Great North Road Solar and Biodiversity Park

Draft Statement of Common Ground with Nottinghamshire County Council

Document reference – EN010162/APP/8.4A1B

~~January~~February 2026

0 0.25 0.5 1 km

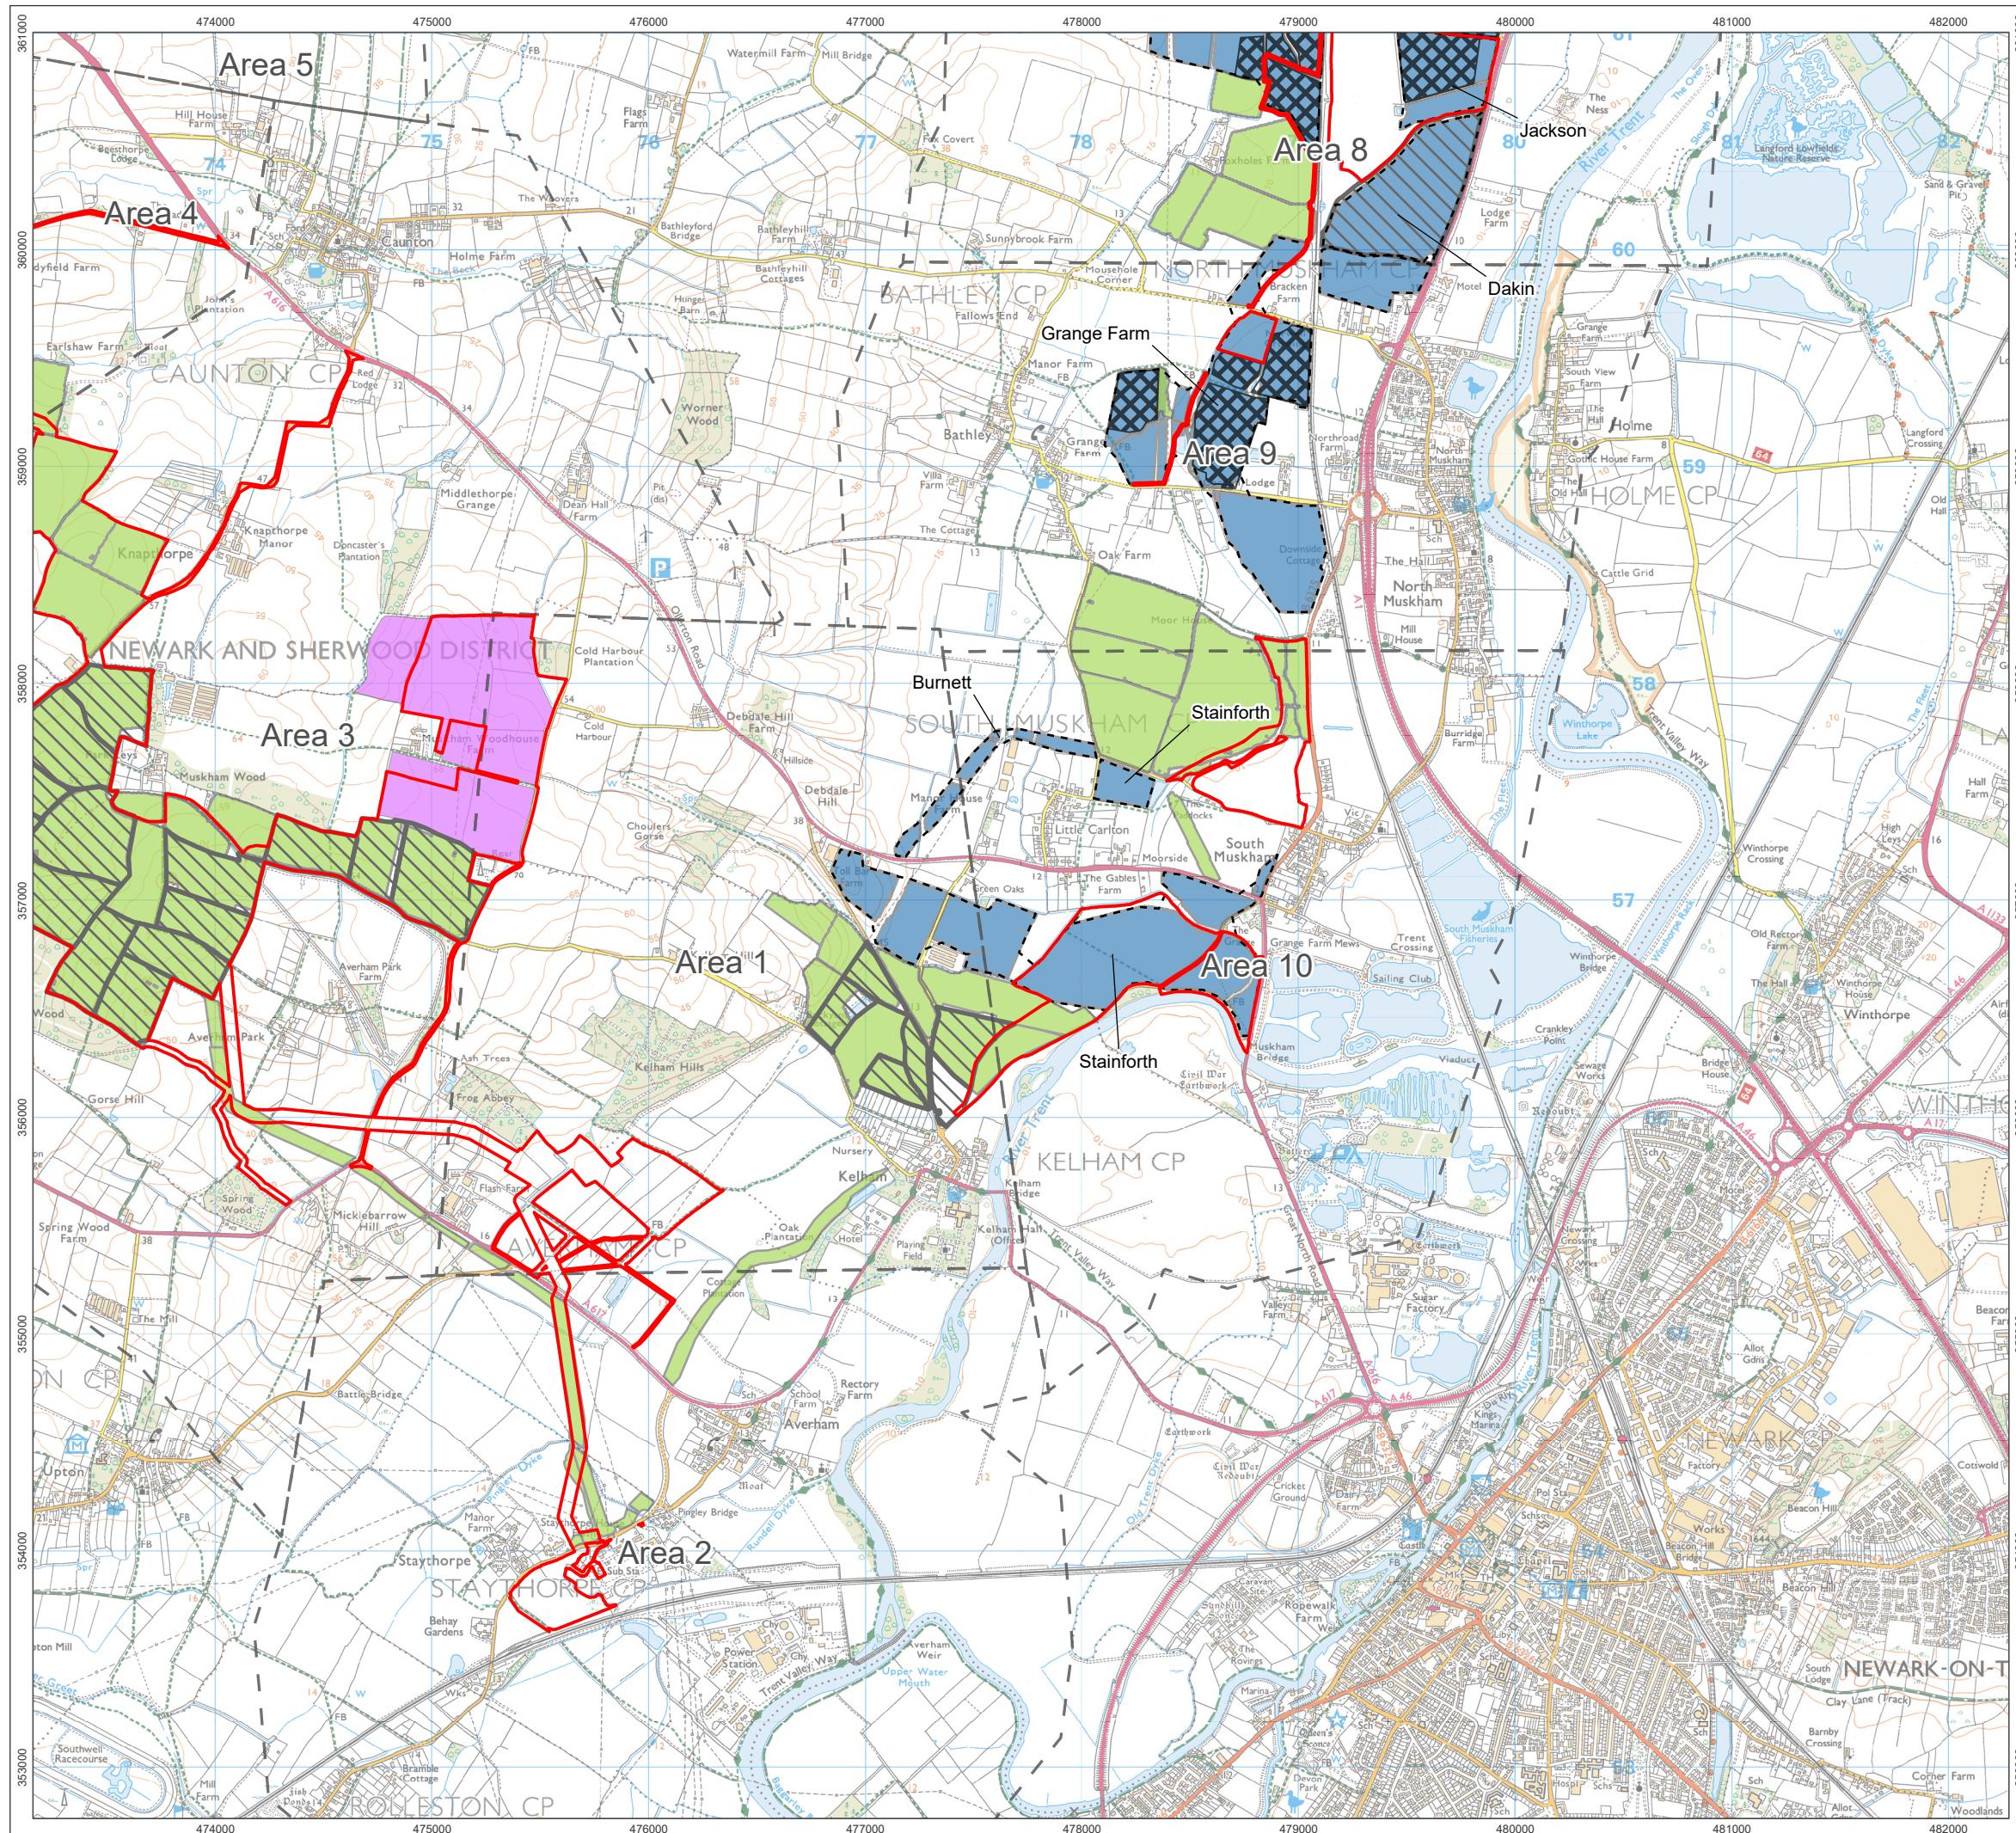
Ref	Relevant Documents	Description of Matter	Applicant's <u>NCC's</u> Position	<u>NCC's</u> Applicant's Position	Status
			<p>data to inform the <u>ES is welcomed.</u></p> <p><u>In regard to the completeness of survey to date it should be noted that geophysical baseline survey coverage was c.90% and that trenching tested all geologies. This is considered to be proportionate, in line with developing best practice guidelines and sufficient to inform the ES for the Environmental Statement (ES) and an initial phase(s) of trial trench evaluation.</u></p> <p><u>The scope of post-consent investigation. However, the applicant acknowledges that the geophysics results have not been tested in their entirety (Para. 48) which we consider a serious limitation when undertaking an appropriate assessment and gathering sufficient data to inform significance and impact.</u></p> <p><u>However, the OAMS has made provision for which is set out in the OAMS, will post consent geophysics and trial trench evaluation work that will</u></p>	<p>the majority of the order limits. This to date has been largely sufficient to provide an acceptable level of data to inform the <u>ES is welcomed.</u></p> <p><u>In regard to the completeness of survey to date it should be noted that geophysical baseline for the Environmental Statement (ES) and an initial phase(s) of trial trench evaluation survey coverage was c.90% and that trenching tested all geologies. This is considered to be proportionate, in line with developing best practice guidelines and sufficient to inform the ES.</u></p> <p>However, the applicant acknowledges that the geophysics results have not been tested in their entirety (Para. 48) which we consider a serious limitation when undertaking an appropriate assessment and gathering sufficient data to inform significance and impact.</p> <p>However, the OAMS has made<u>The scope of post-consent investigation, provision for post</u></p>

Ref	Relevant Documents	Description of Matter	<u>Applicant's</u> <u>NCC's</u> Position	<u>NCC's</u> <u>Applicant's</u> Position	Status
			<p><u>characterise the archaeology and assess impact.</u></p> <p>It is expected that the post-consent investigation and subsequent mitigation will be developed in line with emerging best practice as set out in Archaeology and Solar Farms: Good Practice Guide: A toolkit for developers, archaeological advisers, consultants and contractors.</p> <p>ES Volume 4, Appendix A11.8: Outline Archaeological Mitigation Strategy (AMS) [EN010162/APP/6.4.11.8A] has been updated at Deadline 2 to address the matters highlighted by NCC in respect of the programme of works and</p> <p><u>During the examination period, we would expect to further refine the OAMS in consultation with the applicant and their consultants and agree an outline programme for the post-consent completion of the assessment work. There will also need to be specific wording included in the DCO with respect</u></p>	<p>behind, and details on this will help influence the level of intrusive evaluation required to characterise the archaeology and assess impact.</p> <p>During the examination period, we would expect to further refine the OAMS in consultation with the applicant and their consultants and agree an outline programme for the post-consent completion of the assessment work. There will also need to be specific wording included in the DCO with respect to the archaeology requirement which secures</p> <p><u>It is expected that the post-consent investigation and subsequent mitigation will be developed in line with emerging best practice as set out in Archaeology and Solar Farms: Good Practice Guide: A toolkit for developers, archaeological advisers, consultants and contractors.</u></p> <p><u>ES Volume 4, Appendix A11.8: Outline Archaeological Mitigation Strategy (AMS) [EN010162/APP/6.4.11.8A] has</u></p>
